From: Louisa Walker [REDACTED]
Sent: 11 August 2026 10:28
To: Planning; [REDACTED]
Subject: Applicant Response to Third Party Comments – Planning Application 3/2026/0452

drawing:
Proposed Elevations

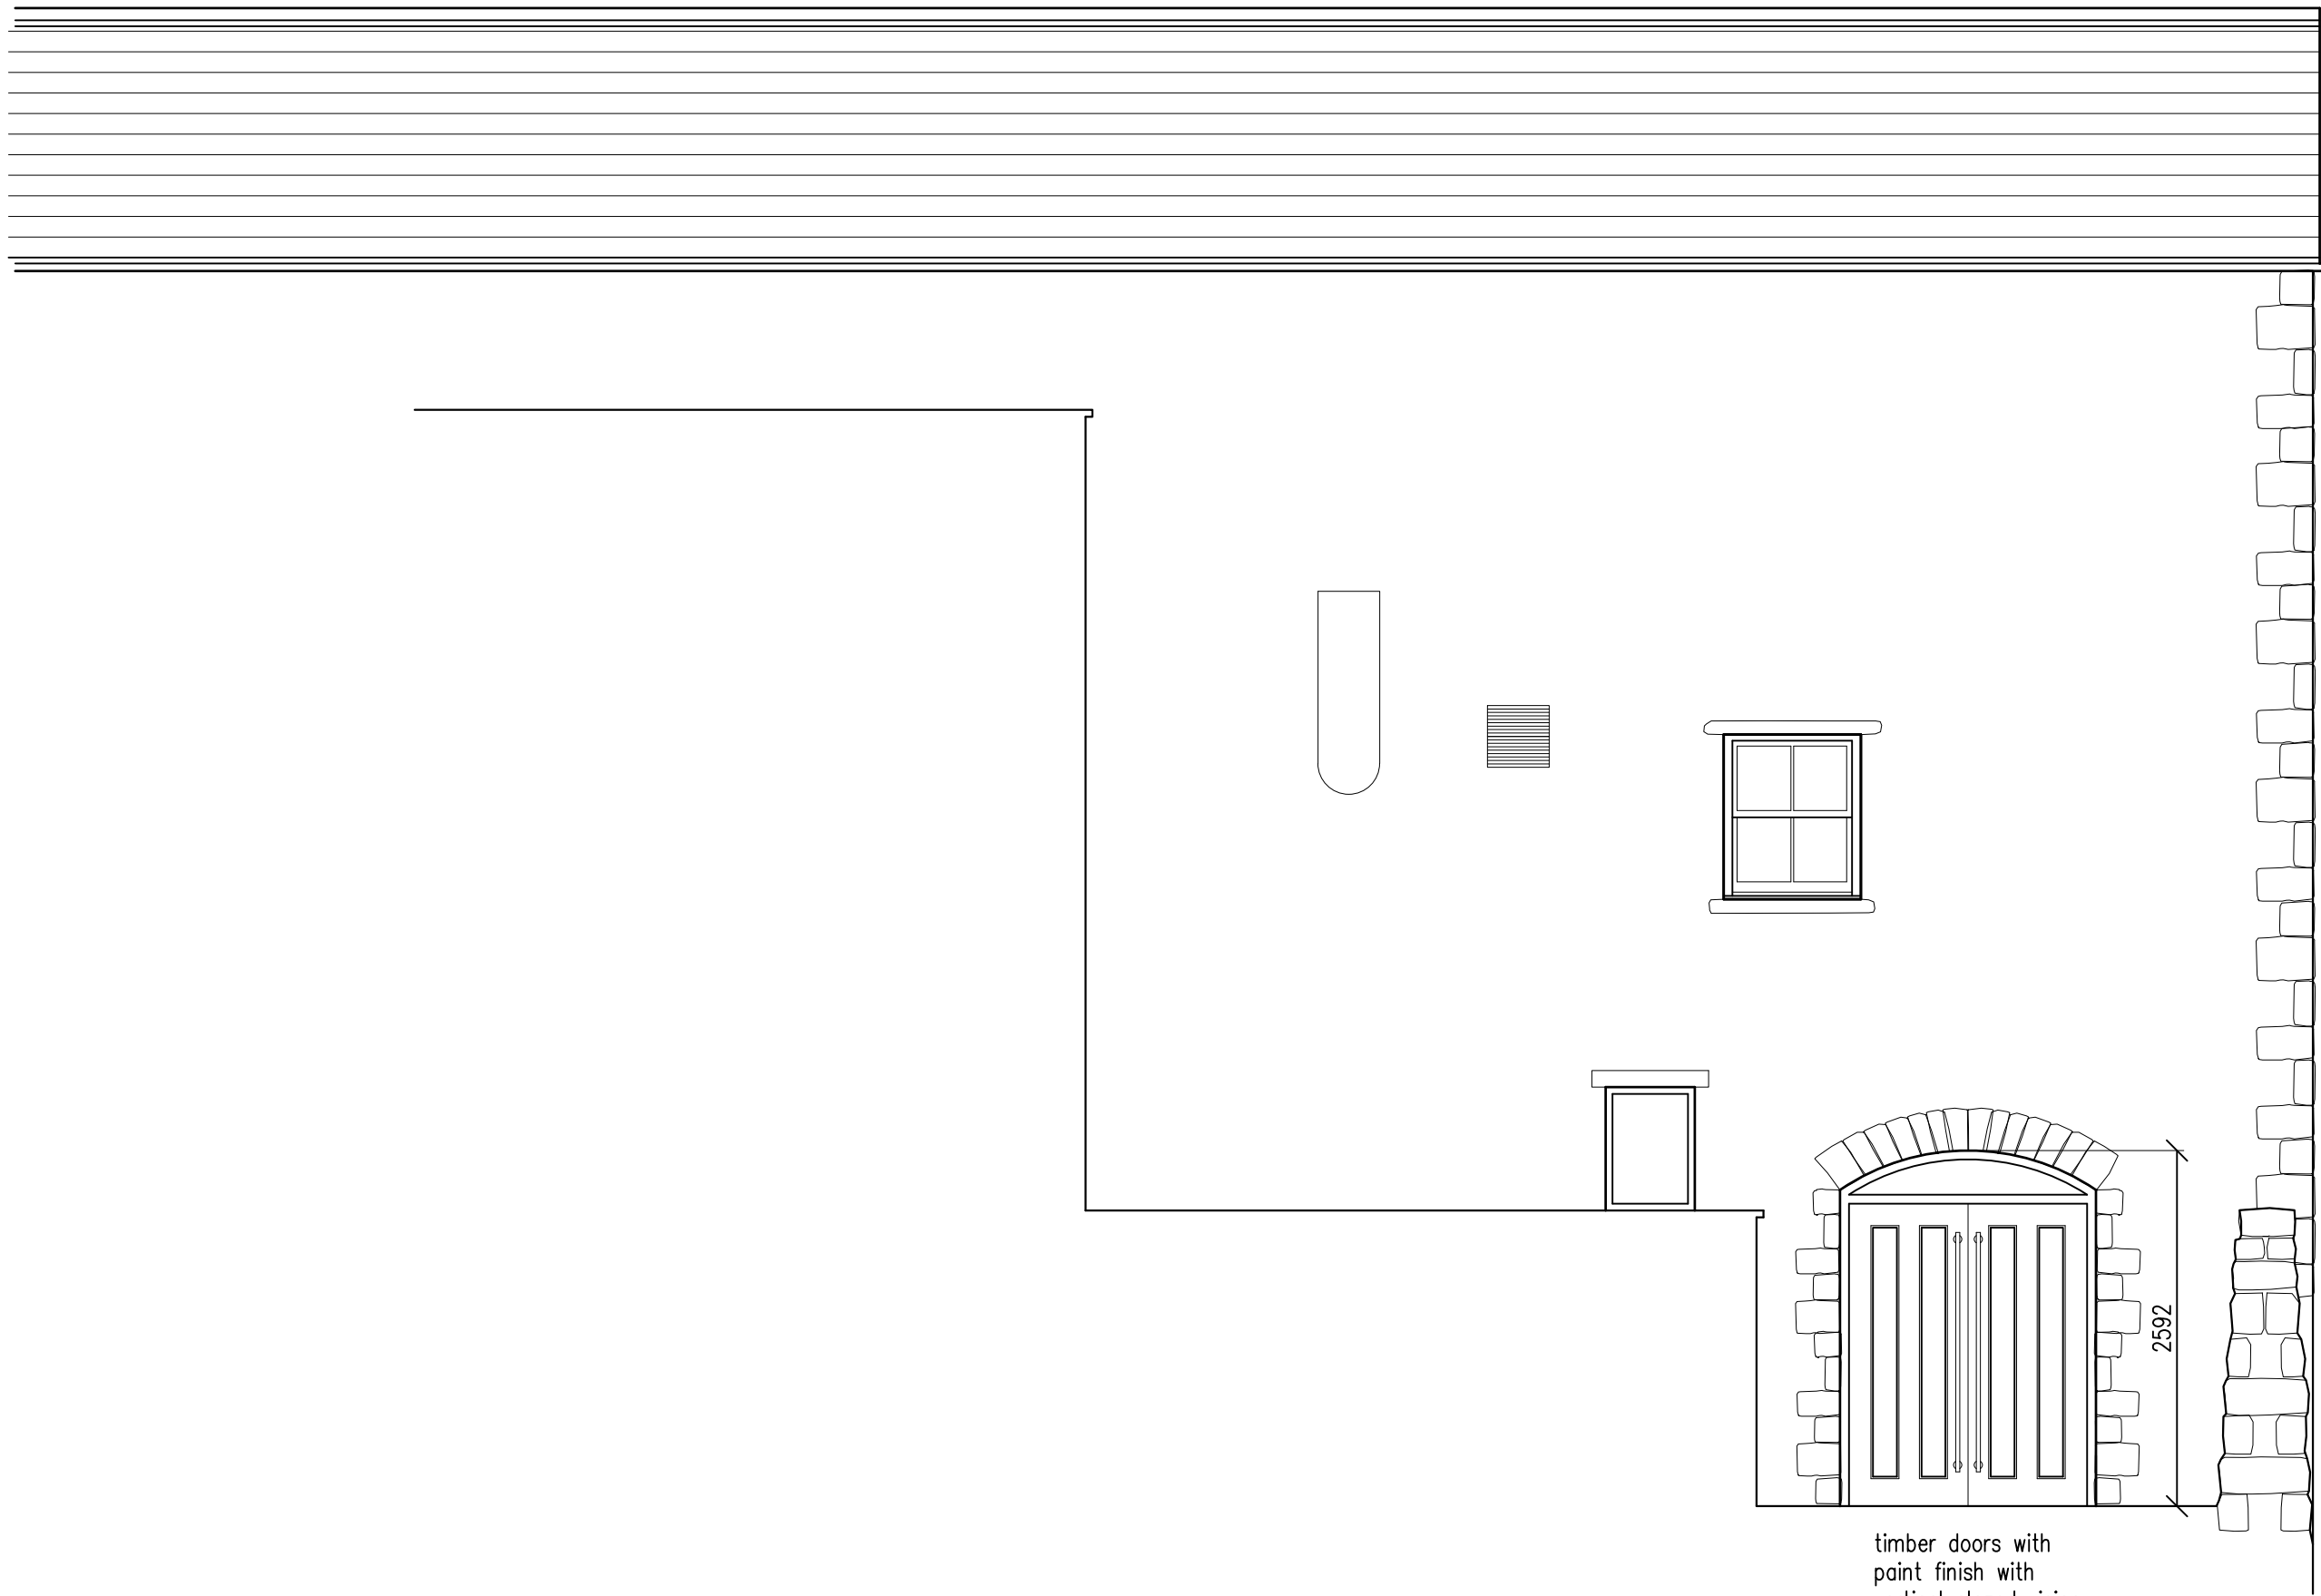
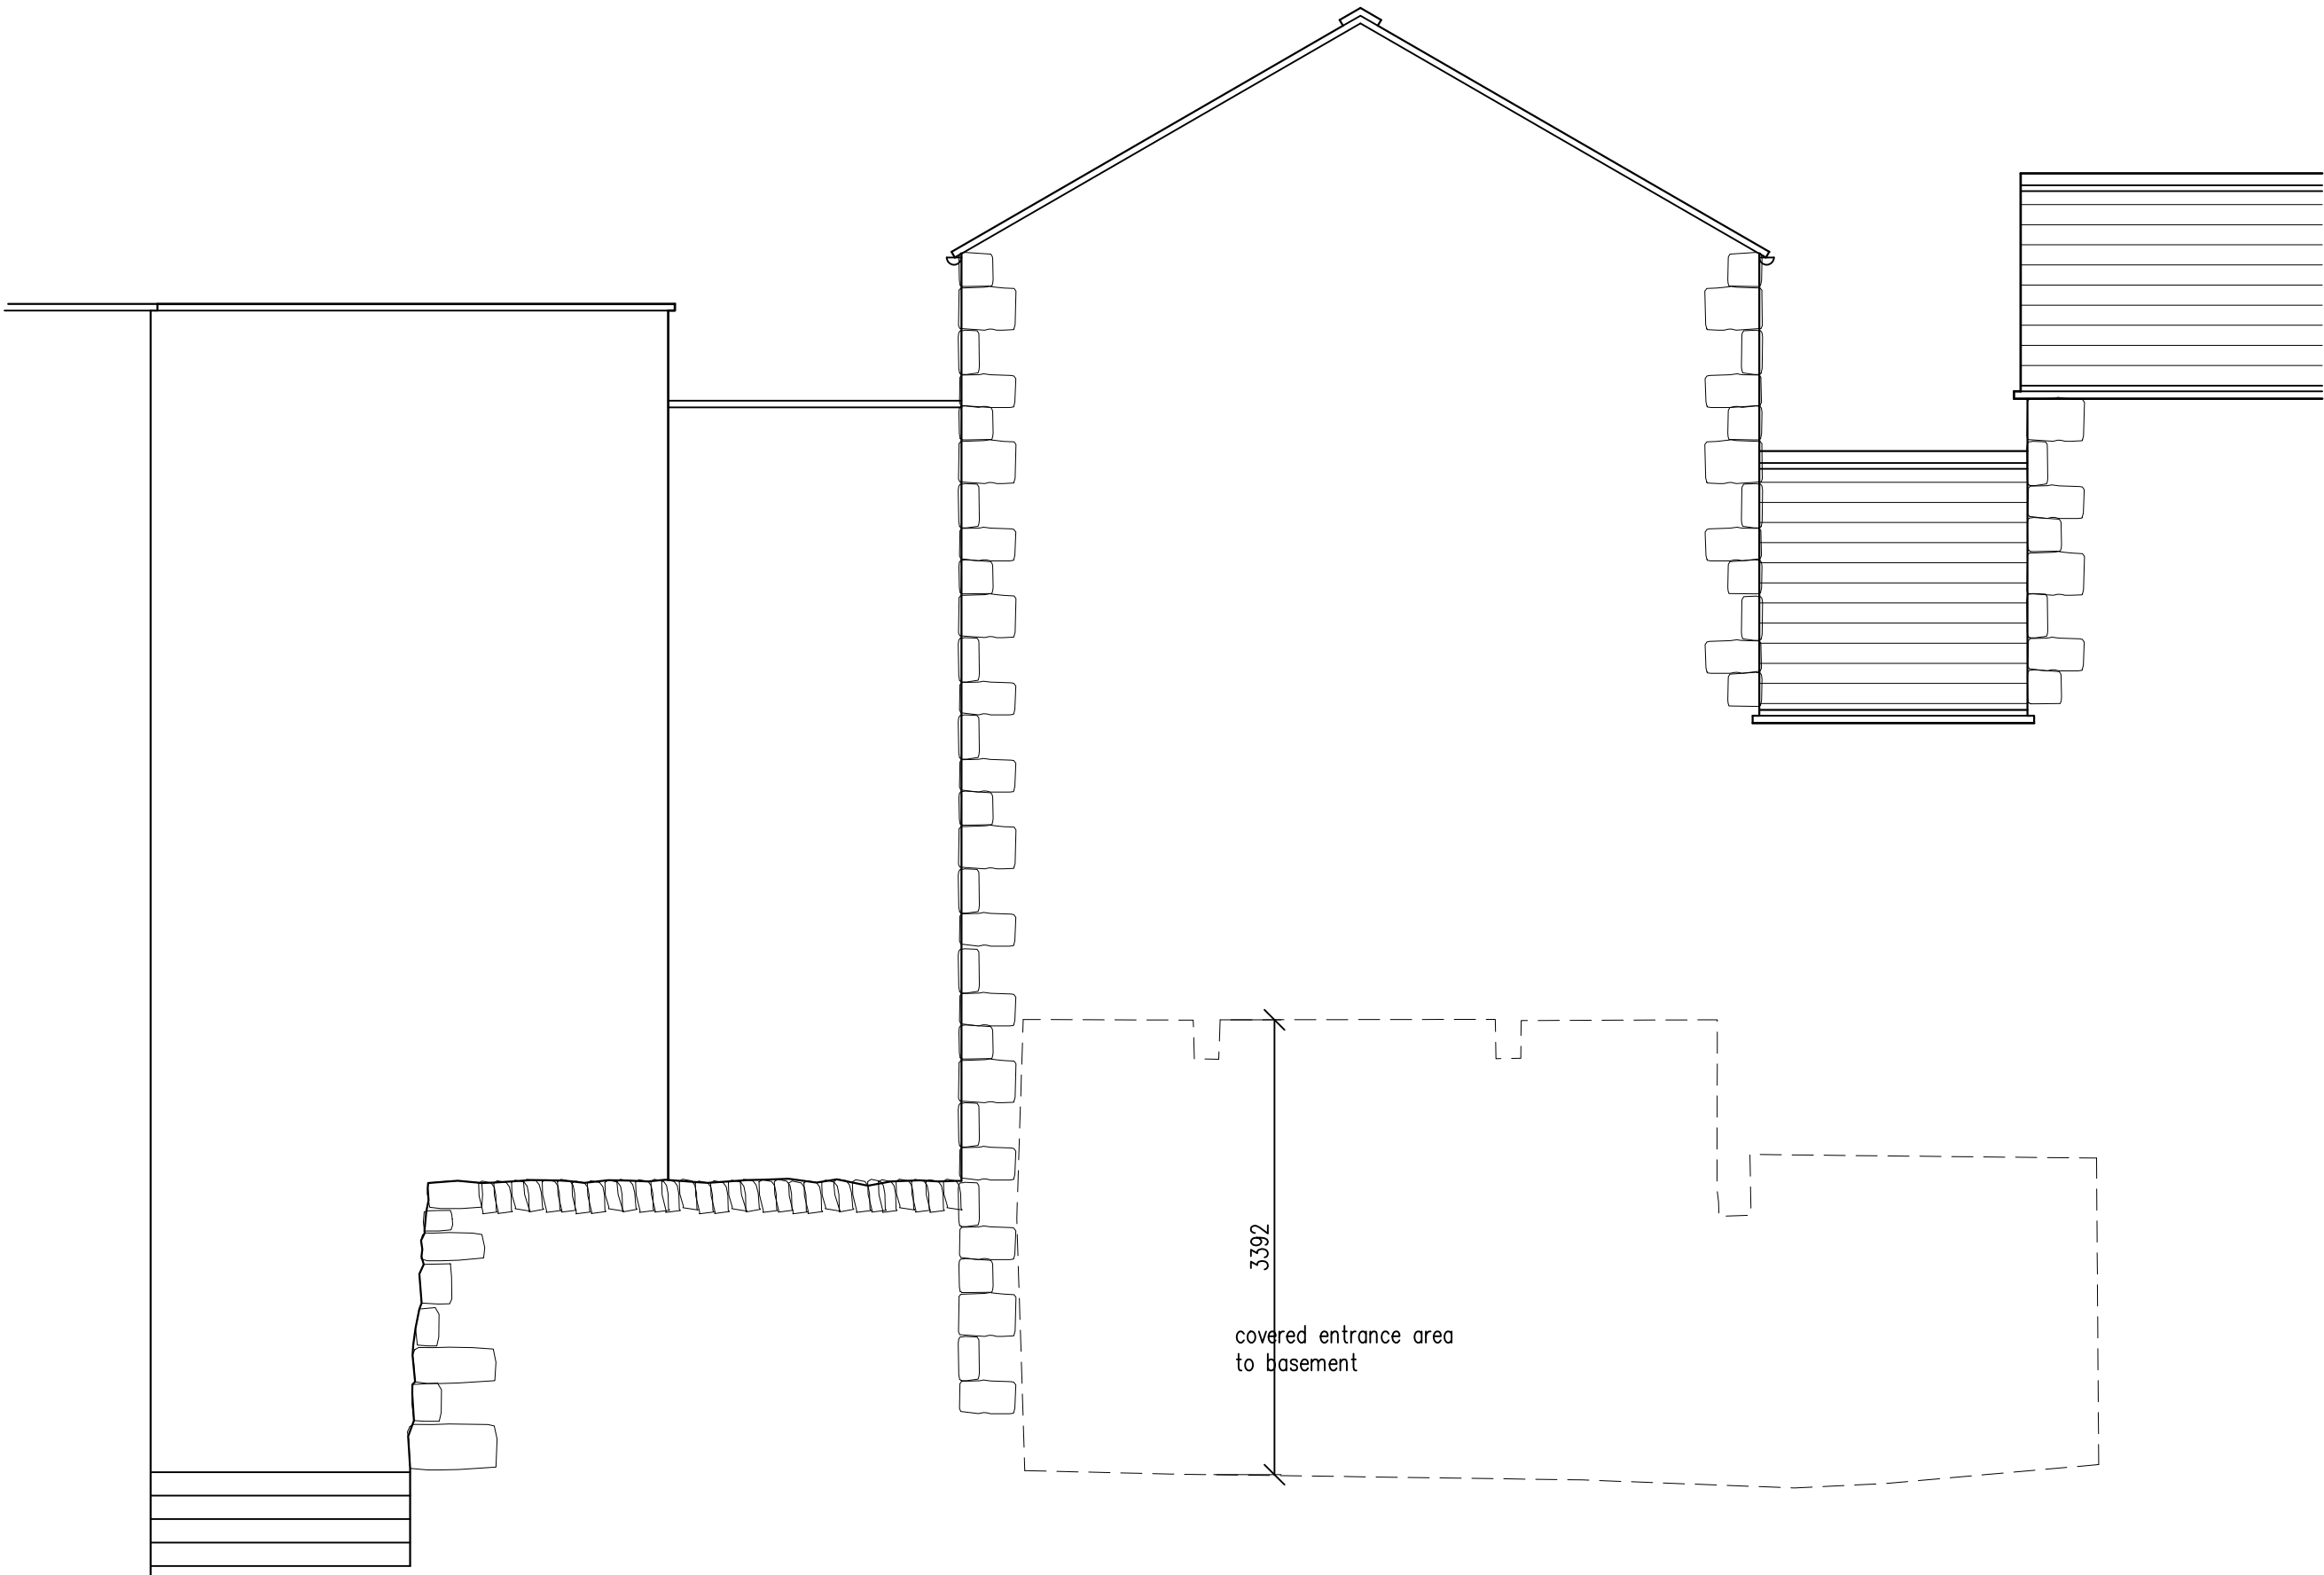
2. Doors within the Existing Archway

We can confirm that the proposed doors are intended to remain open at all times during normal operating hours and are not intended to restrict public access between Lowergate Car Park and Swan Courtyard. The doors will not have keyholes and are not designed to be locked in a manner that would impede pedestrian access through the archway.

It is not our intention to obstruct or restrict this established pedestrian route, and we trust that this clarification addresses the concerns raised.
